Office of
Environment
& Heritage

DOC15/458870
SSD 6917

Oakdale South Industrial Estate, Erskine Park, Penrith LGA (SSD 6917) Notice of Exhibition

ATTACHMENT 1 Office of Environment and Heritage Comment on public exhibition of Oakdale South Industrial Estate, Erskine Park, Penrith LGA (SSD 6917).

GENERAL ARRANGEMENT PLAN

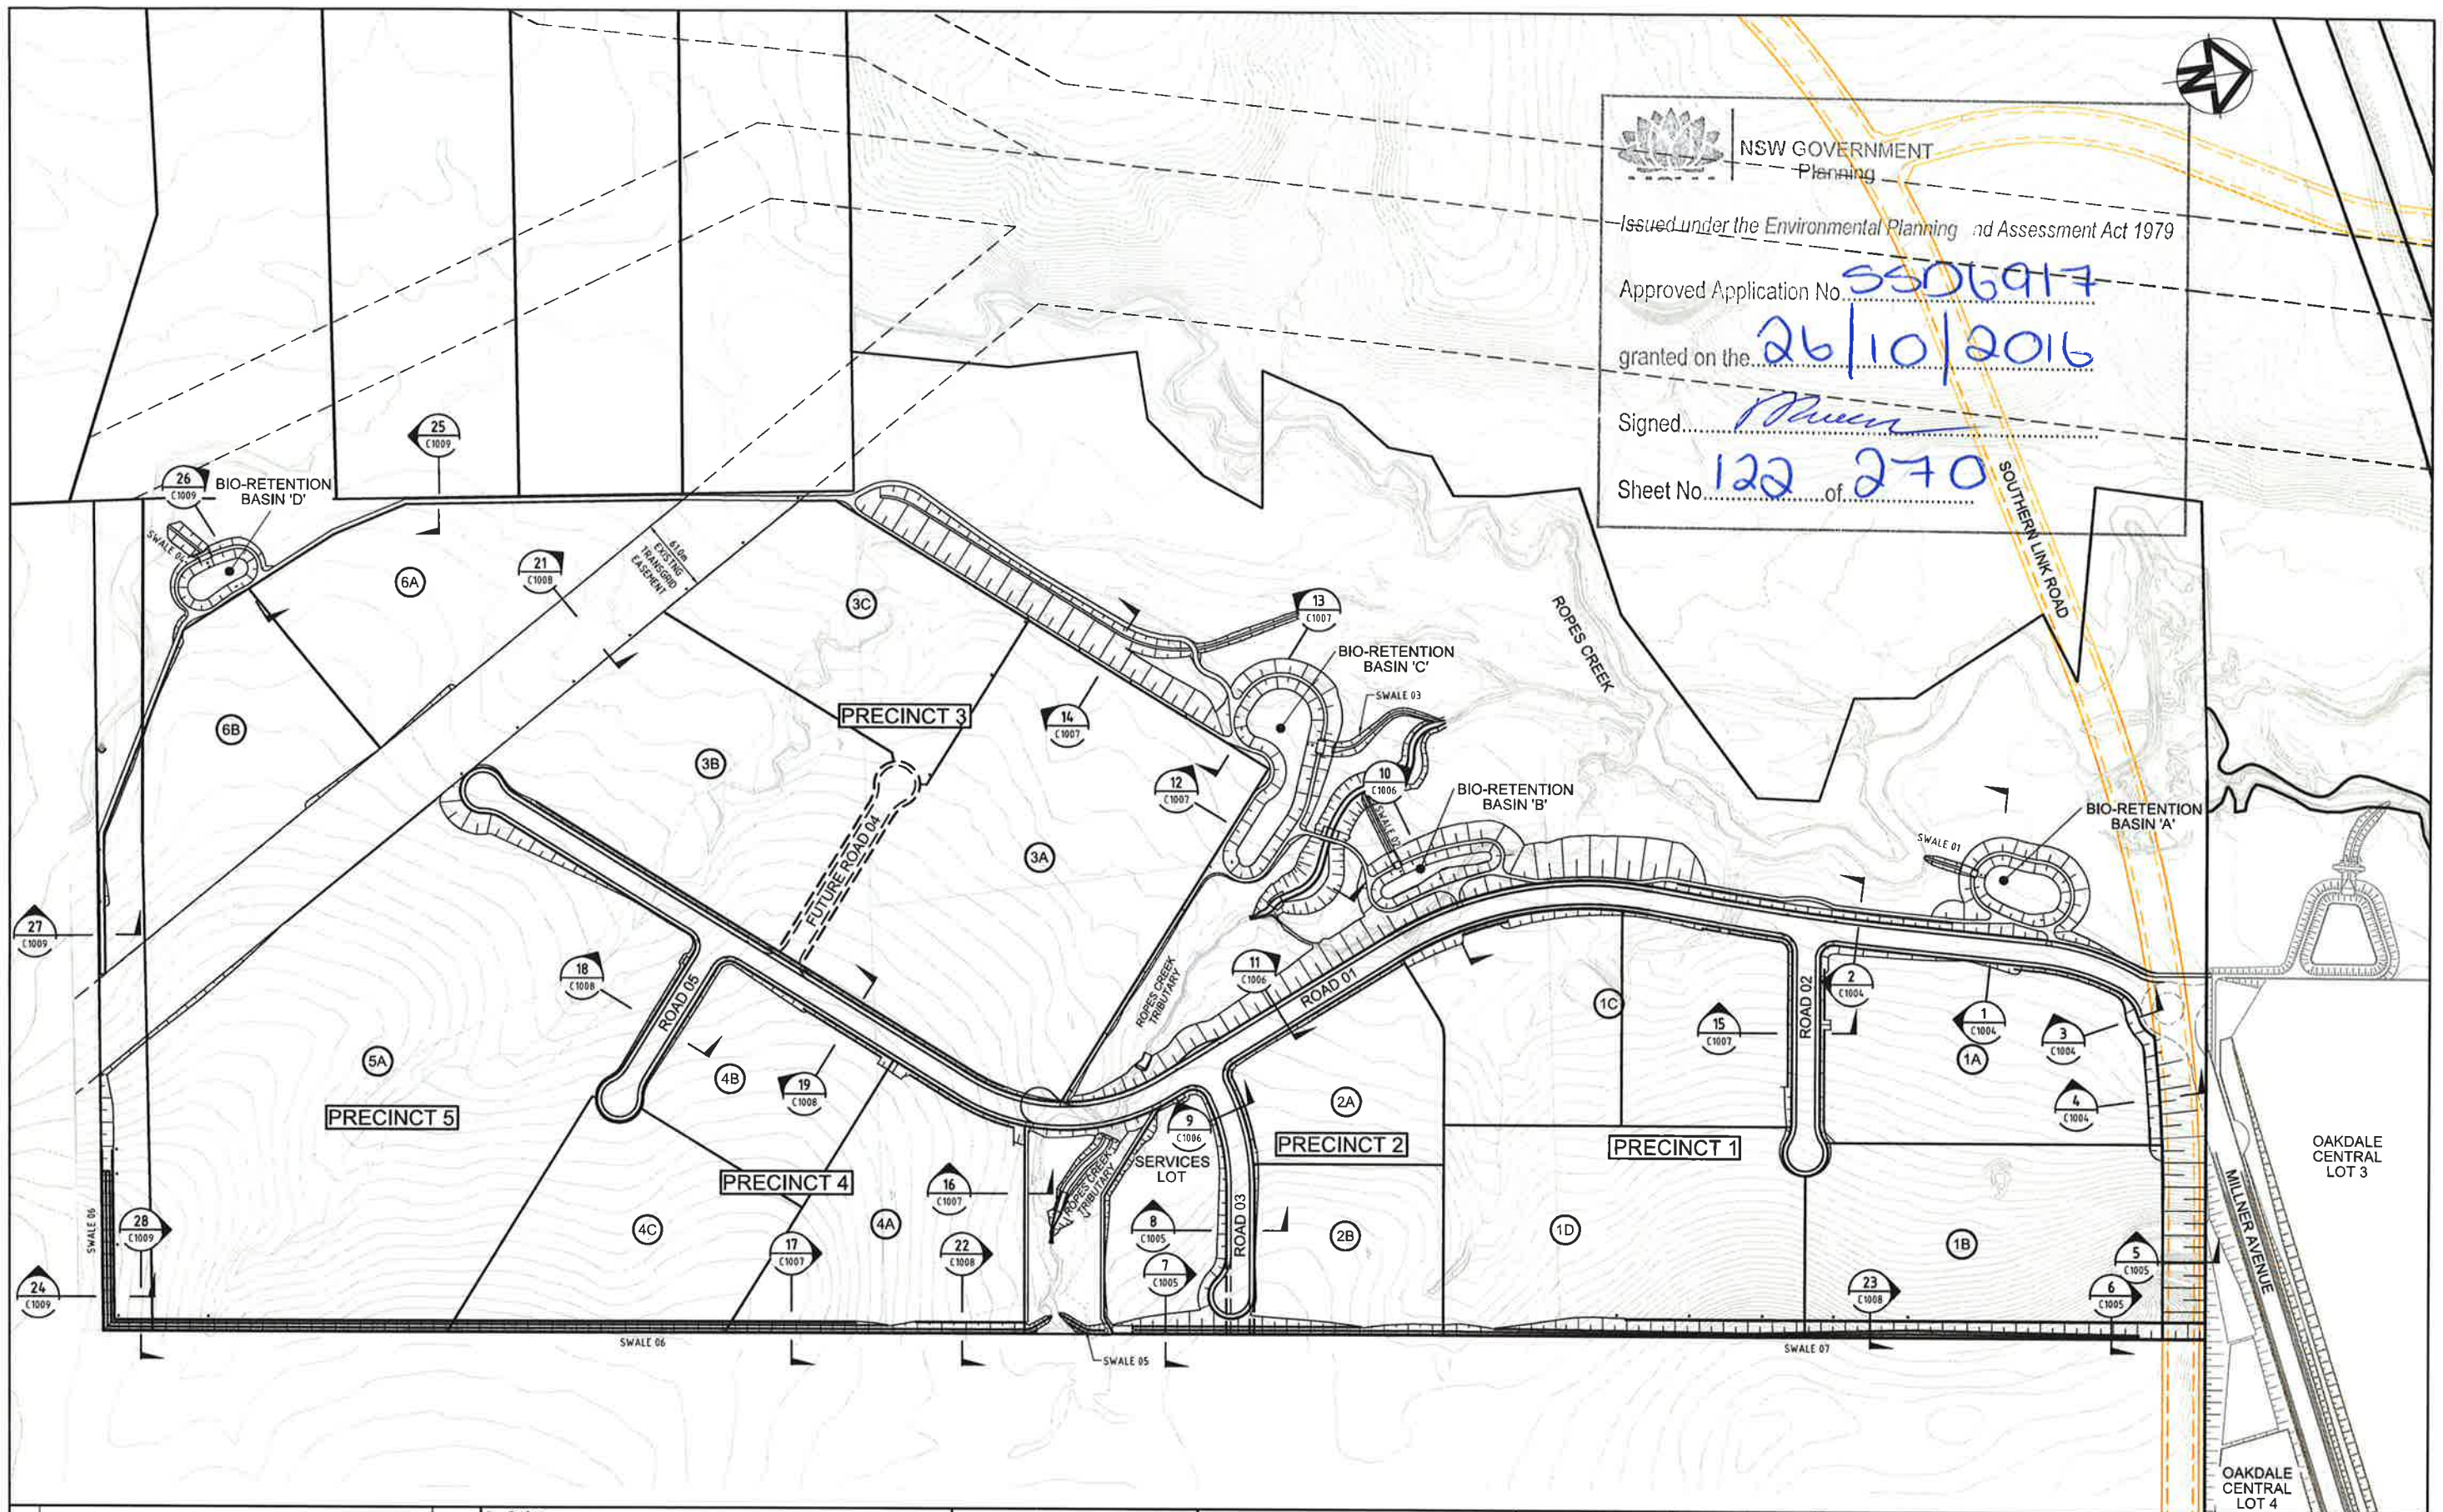
The only map that shows the E2 zoning is Figure 16 of the EIS and the permissibility and conformance with zone objectives is not discussed. The indicative layout of the development site Figure 1.3 in the Cumberland Ecology report shows the road, services lot and batter within E2 land. The proposal would entirely remove the eastern section of the tributary and require the realignment of a section of it to accommodate the road layout.

OEH recommends: that all impacts on the E2 land should be avoided.

RE-ALIGNMENT
CREEK 2

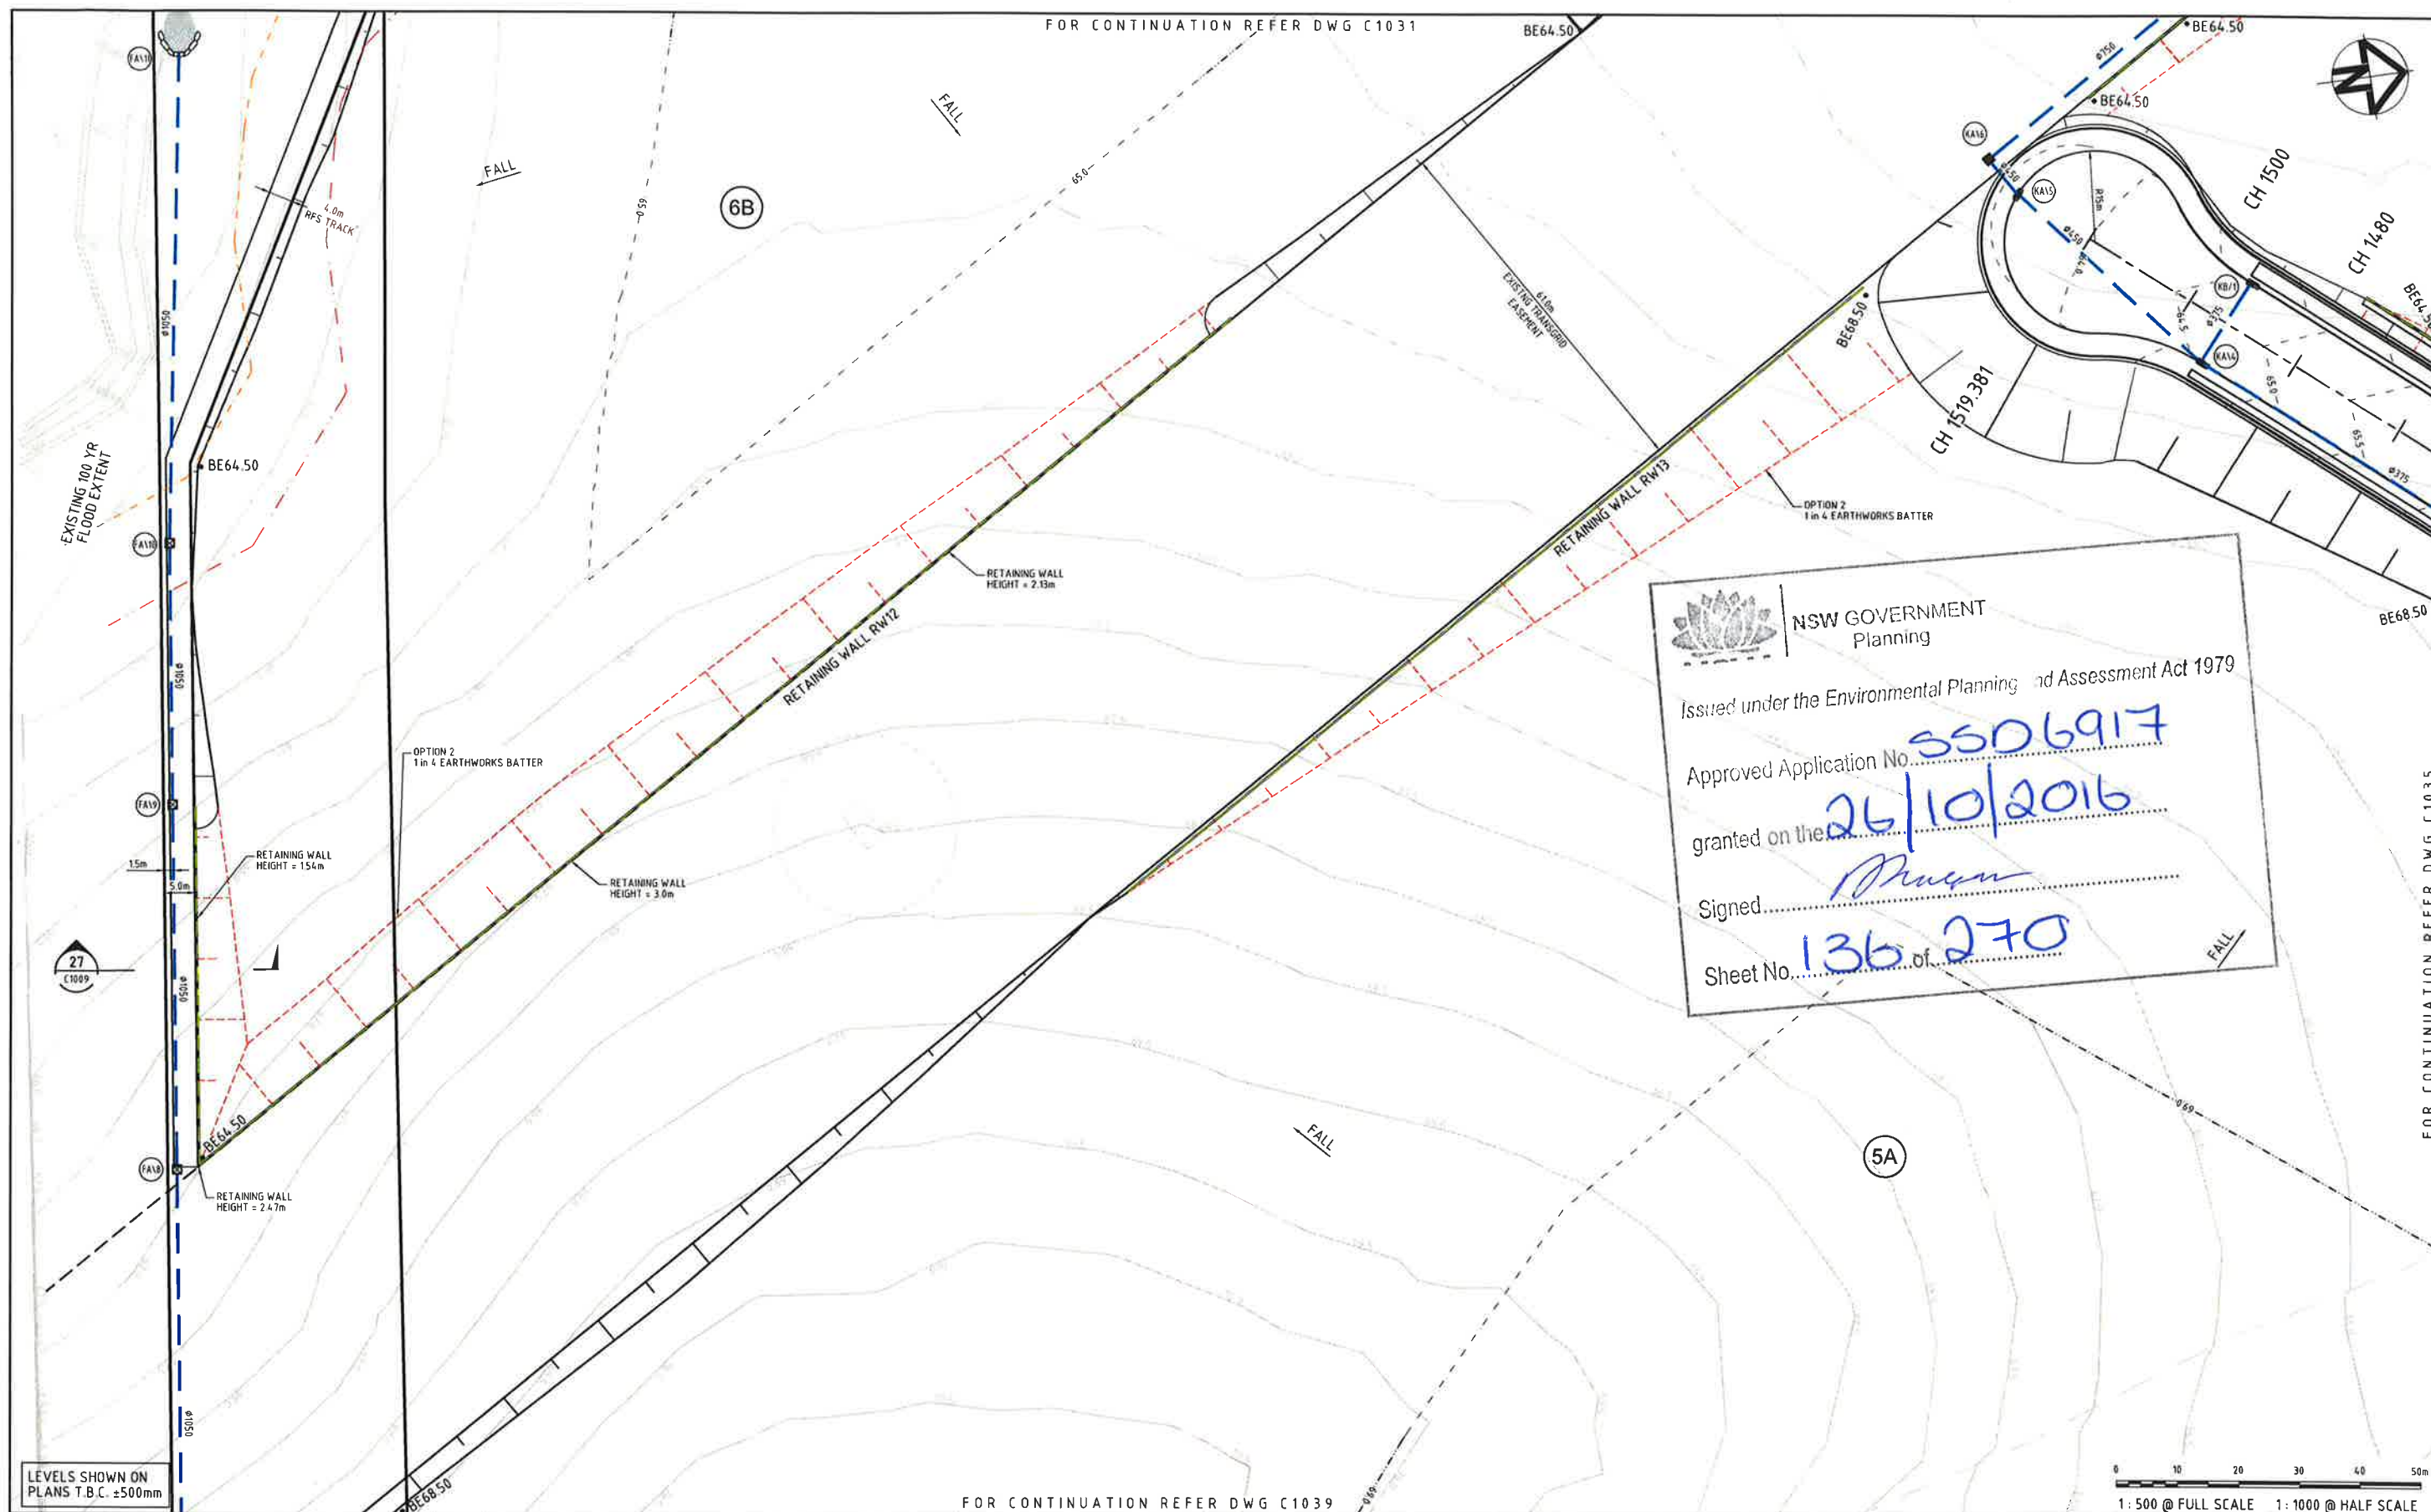
The Oakdale South Industrial Estate proposal involves filling in a creek that drains the southern portion of the development site, re-grading the site and draining the site through roadways and piped flow into retention basins that flow into Ropes Creek. The modelling detailed in the report titled *Flood Impact Assessment Oakdale South Industrial Estate* (Cardno, 16 September 2015) shows the proposed works would result in minor localised increases and decreases of 100yr ARI flood levels along Ropes Creek and local flood levels increases within the power line easement adjacent to the proposed development.
